Recommendation Report for Planning Permission for Works or Extension to a Dwelling

REF NO: R/32/26/HH

LOCATION: 34 Mallon Dene  
Rustington  
BN16 2JR

PROPOSAL: Single storey rear extension.

DRAWING: 26/04/2

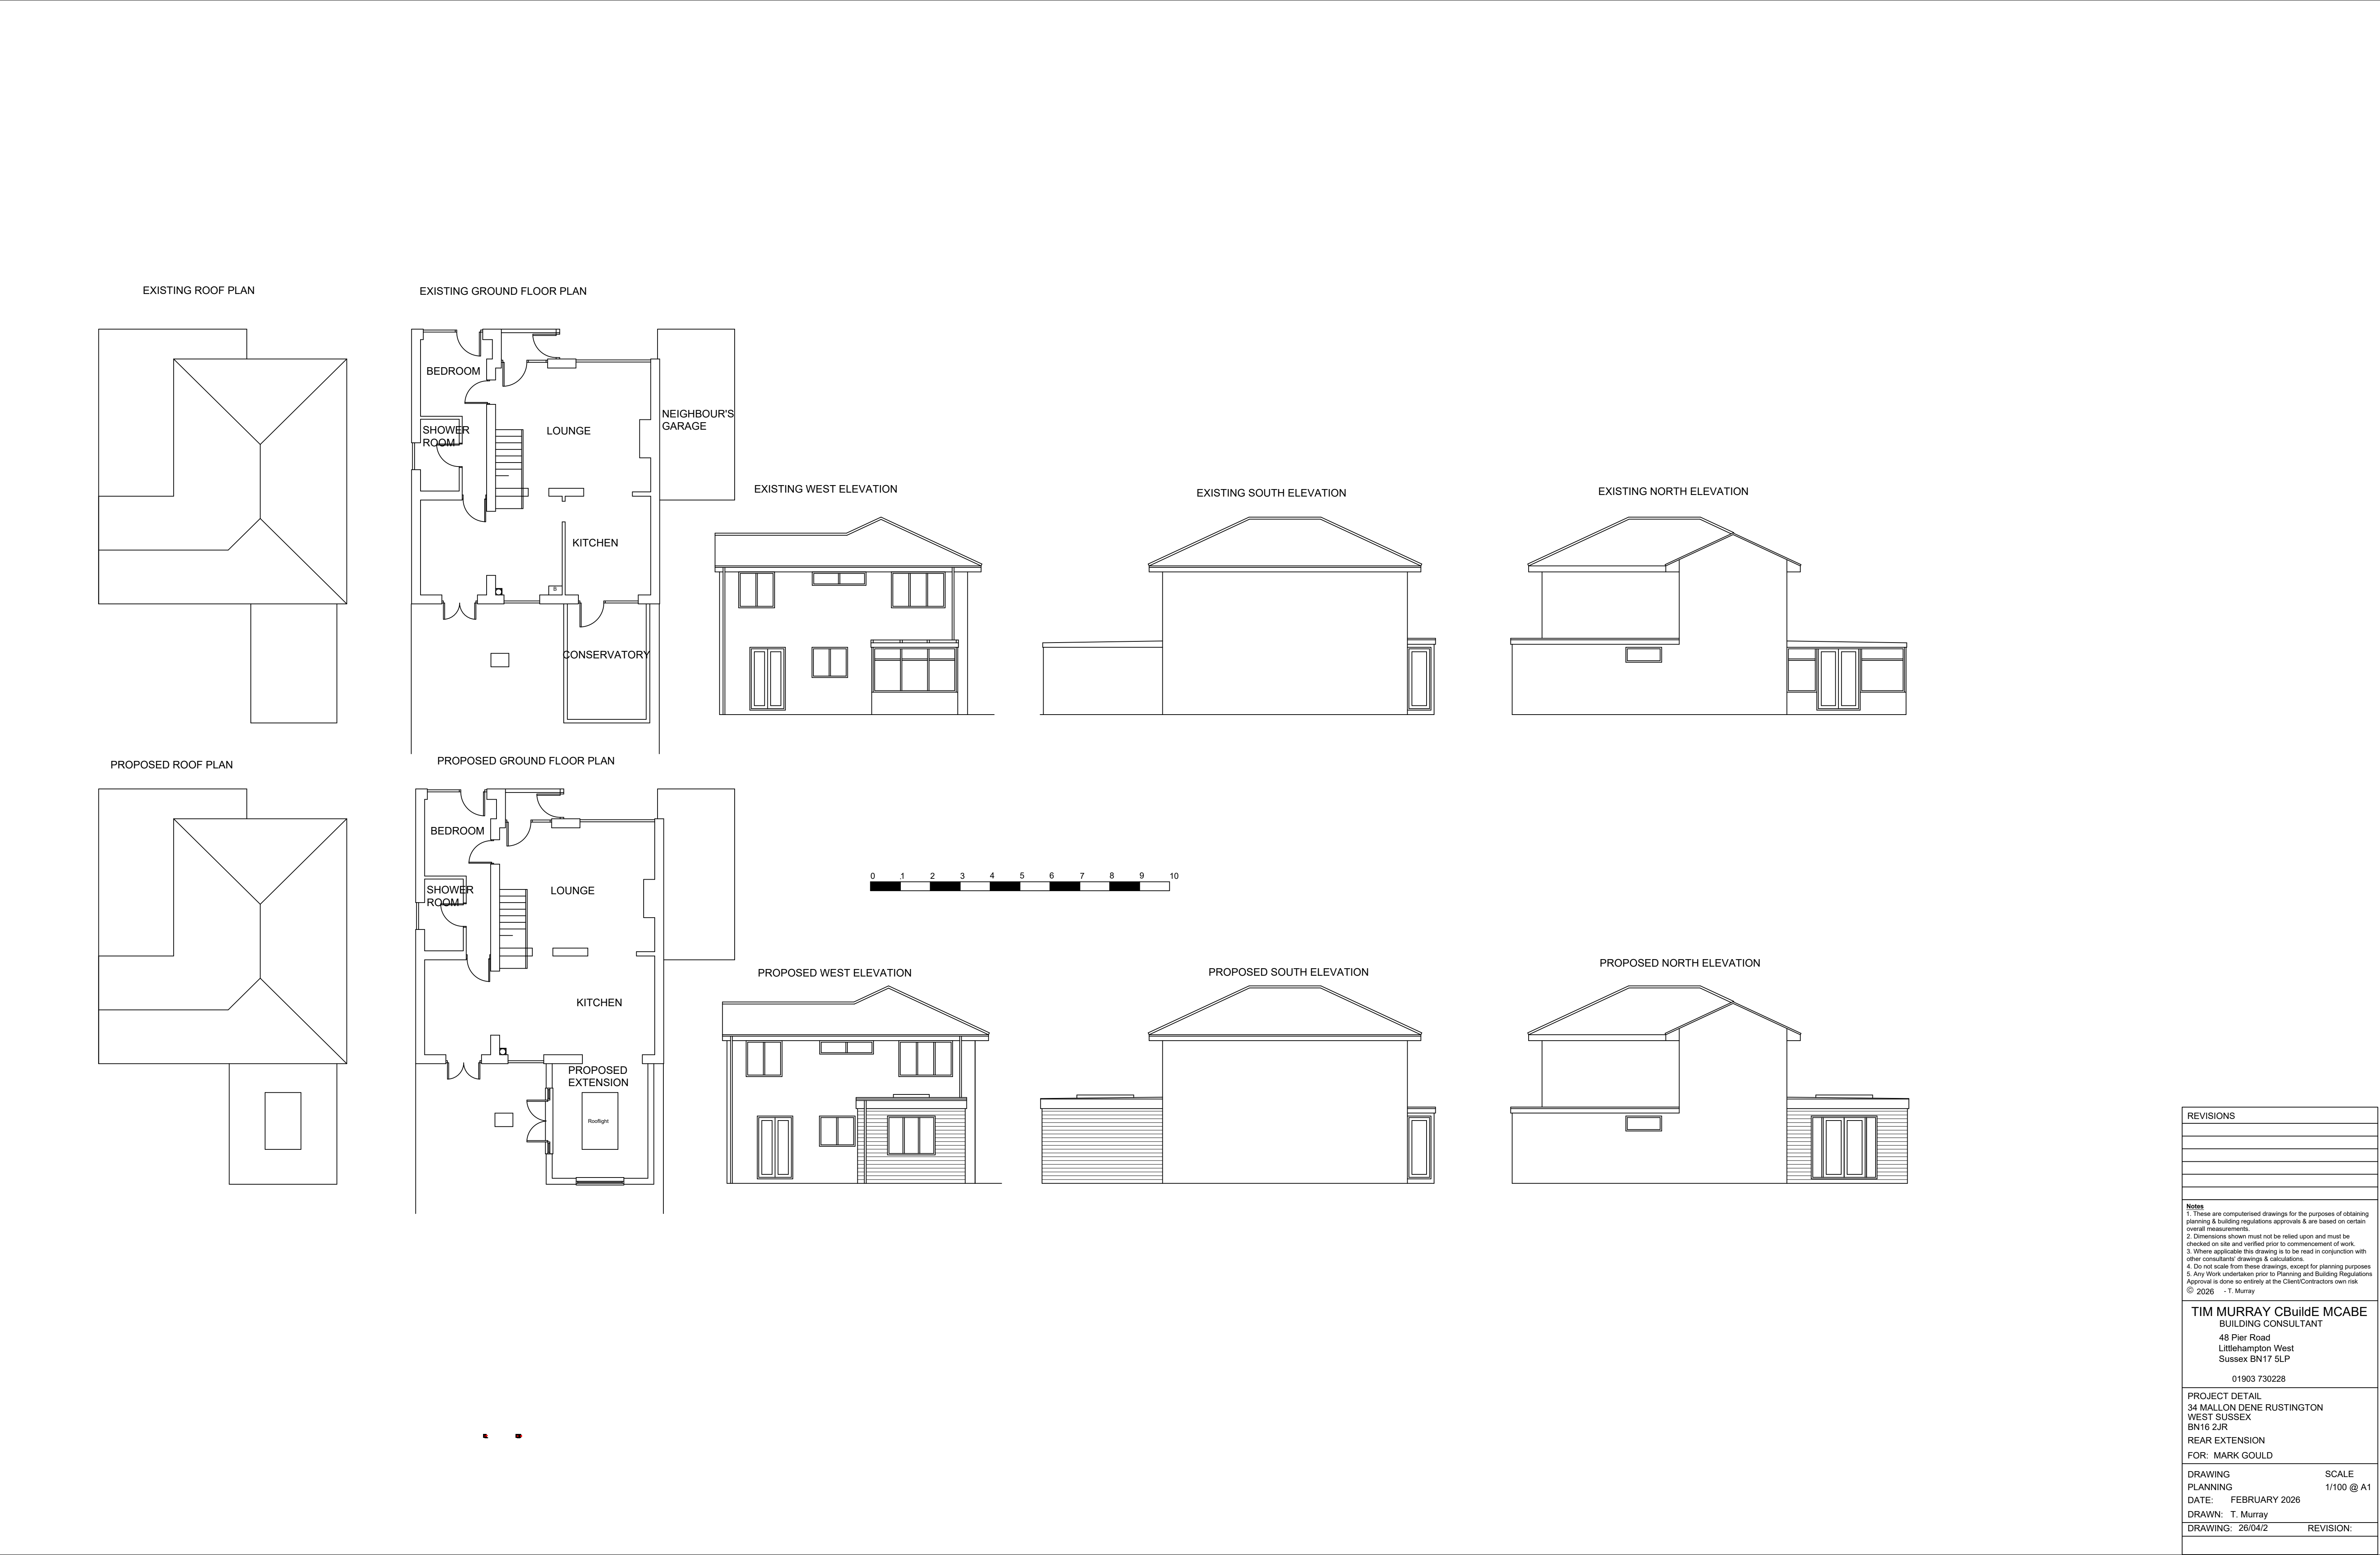
The proposal seeks a planning permission for the construction a single storey rear extension to replace an existing conservatory. The extension would measure approximately 3.6m in width and 4m in depth, and would largely replace the footprint of the existing conservatory. It would feature a flat roof form with a maximum height of approximately 3m.

The proposed fenestration would include a three-pane window within the rear (west) elevation, patio doors on the side (north) elevation, and a rooflight within the flat roof section.

The extension would be finished in composite cladding. While the proposed materials would not match those of the host dwelling, which would not strictly accord with the guidance set out in the Arun Design Guide (ADG), the extension would be sited to the rear of the property and would not be visible from the public realm. In this context, the use of non-matching materials would be acceptable and would not result in harm to the visual amenity of the host dwelling or the surrounding area.

The proposed depth of the rear extension would not comply with the guidance set out in the ADG, which states that single storey rear extensions should not exceed 3.3m in depth. However, the extension would be visually subservient to the host dwelling, it would be positioned to the rear and would not be visible from the public street scene. In addition, similar rear projections are common within the vicinity and the proposed extension would replace an existing conservatory of a similar depth. Therefore, the development would not appear visually intrusive or out of keeping with the character of the surrounding area.

The proposed development would be set in approximately 4m from the northern side boundary and would not project beyond the established built line of the neighbouring dwelling to the north. As such, the extension would not result in any overbearing impact or unacceptable loss of light to this neighbouring property.

The rear extension would be constructed close to the southern side boundary and would be set in approximately 0.3m. The proposal would largely replace the existing conservatory and, when compared to the existing situation, would not introduce any additional overbearing or overshadowing impacts to the neighbouring dwelling to the south.

A glazed door is proposed within the northern flank elevation of the extension. This would be positioned in a comparable location to existing openings, and therefore the proposal would not result in any increased overlooking or loss of privacy to neighbouring occupiers to the north.

The proposed rear (west) window would primarily overlook the private amenity space. No openings are proposed within the southern flank elevation. As such, the proposed extension would not result in overlooking to the neighbour to the south.
